PLANNING APPLICATION REF A1113/21/R
68 THE STREET, RUSTINGTON BN16 3NR

14/6/21

ELEVATION 01

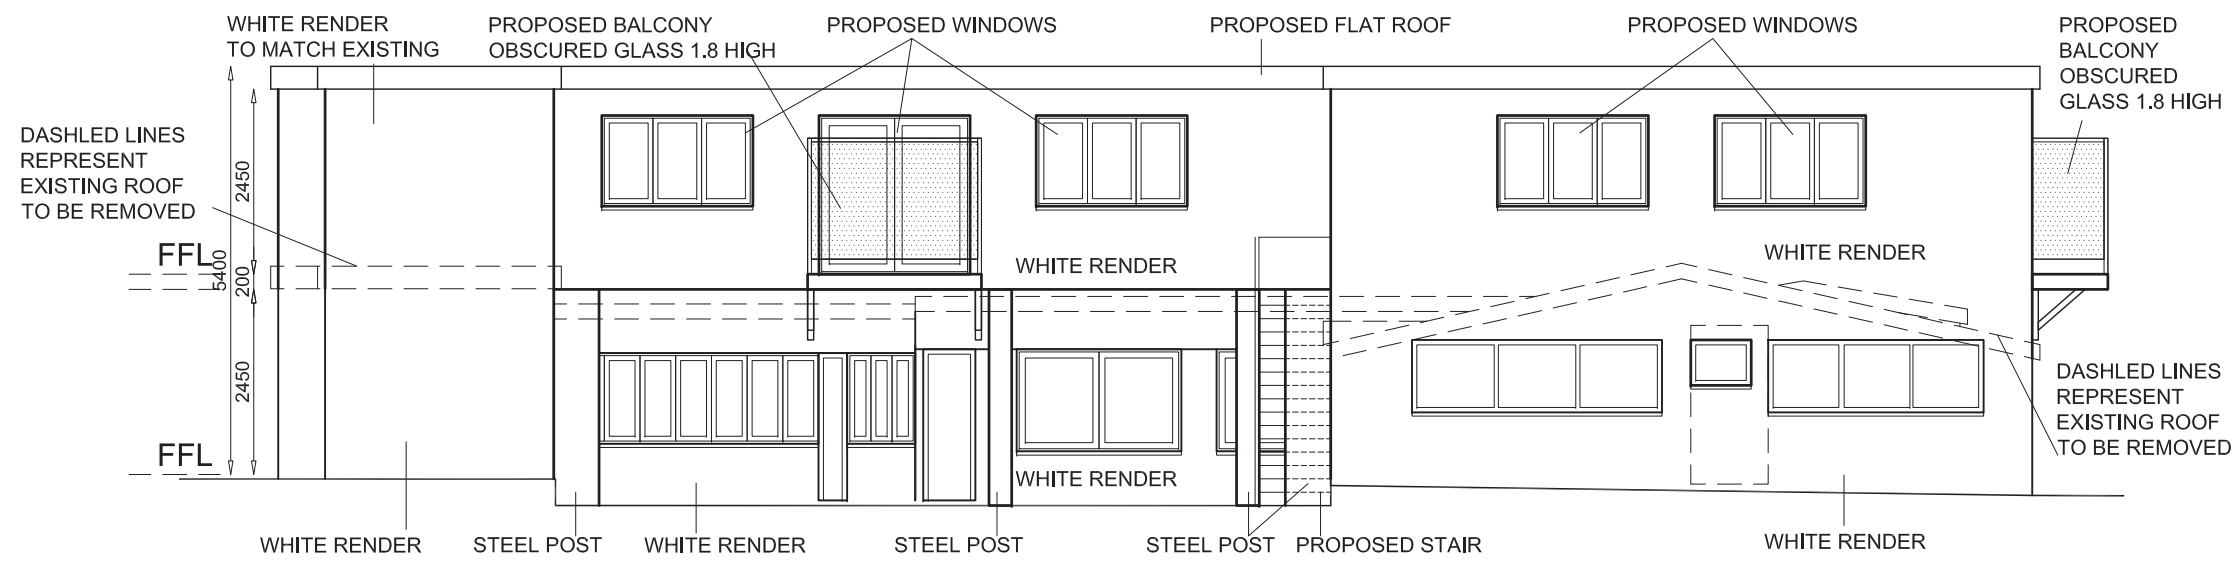
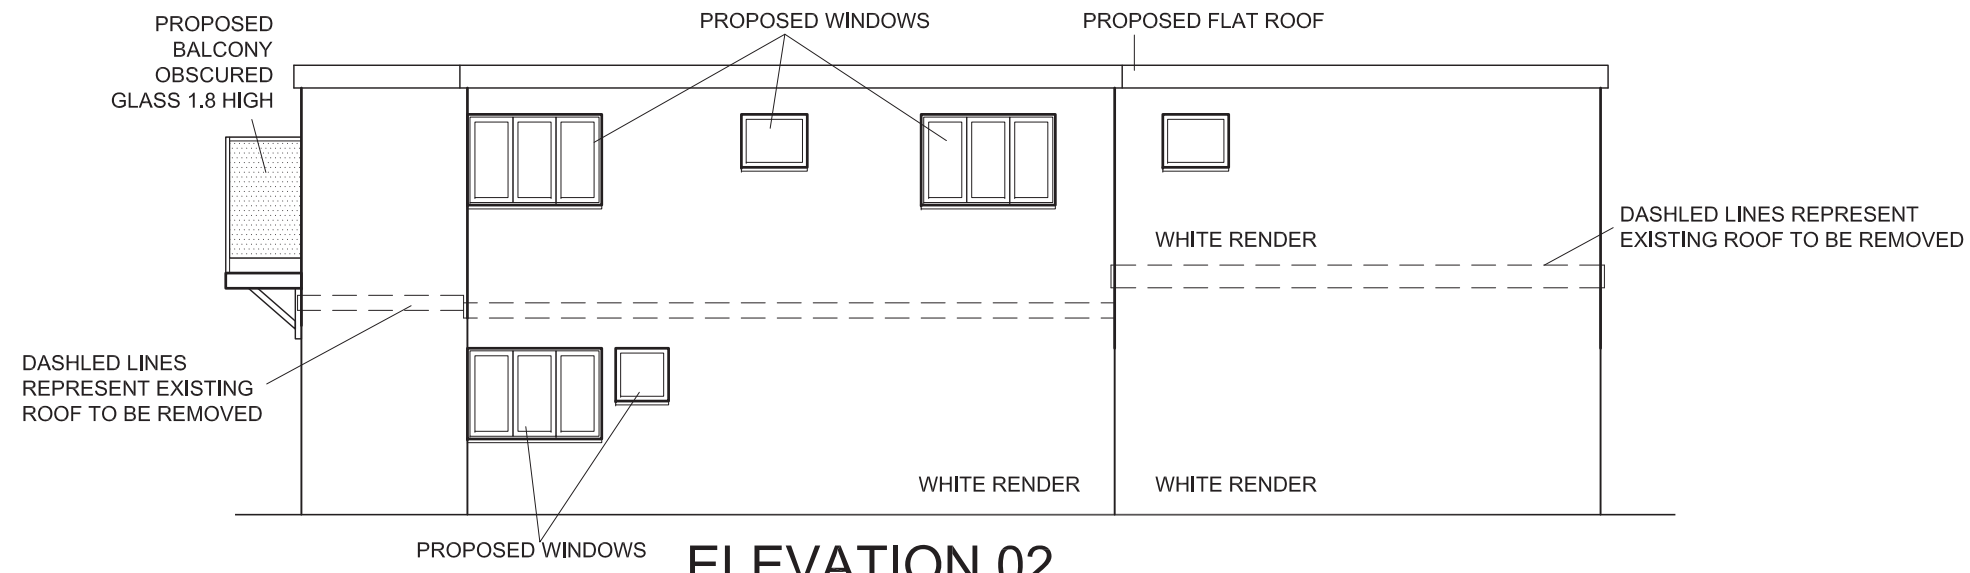
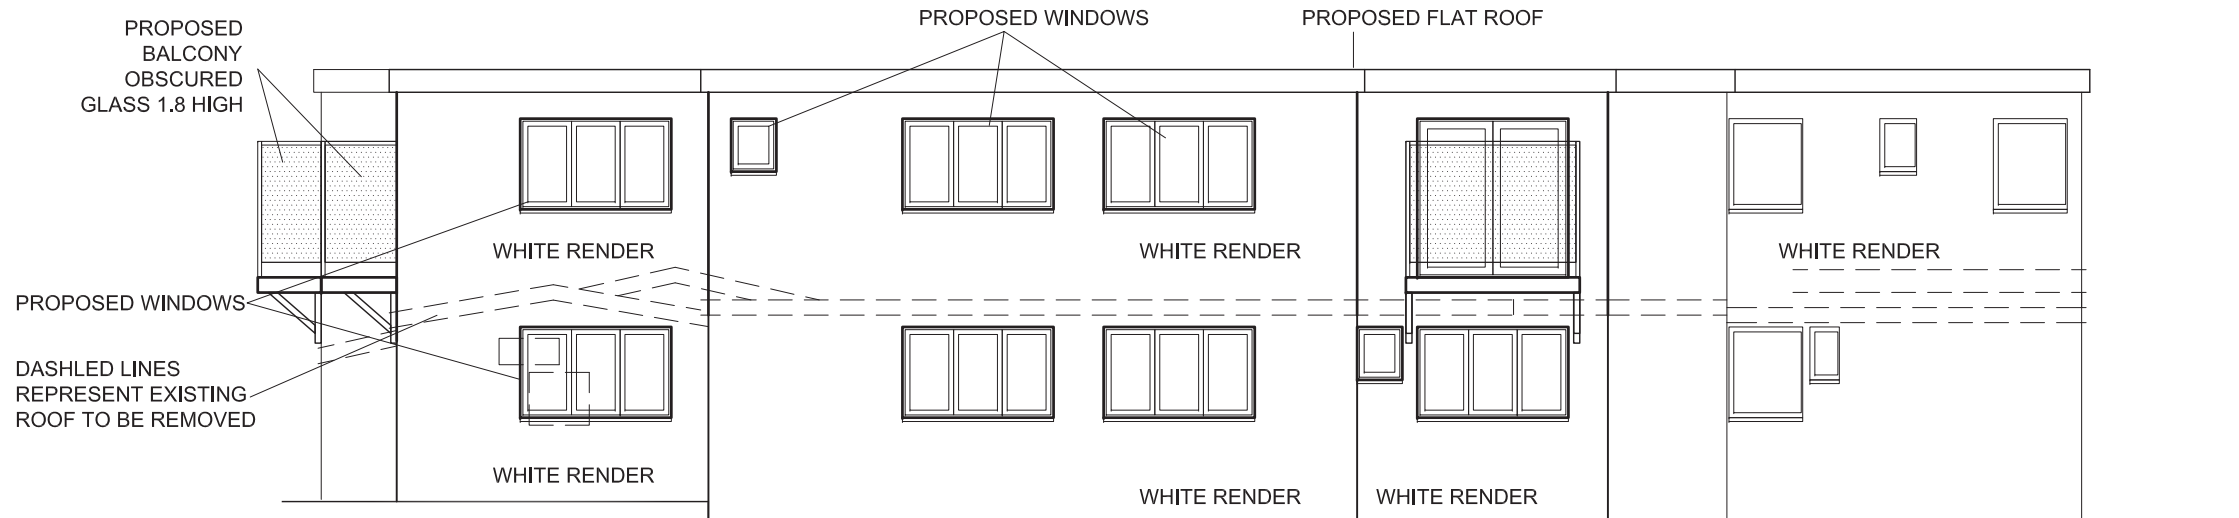
- 2/ The proposed development has some Balconies looking both North and East which are very intrusive. We purchased our Flats for relative peace and seclusion and if the proposed flats have residents with children there are no areas for them to play and it would be dangerous to use the entrance road.
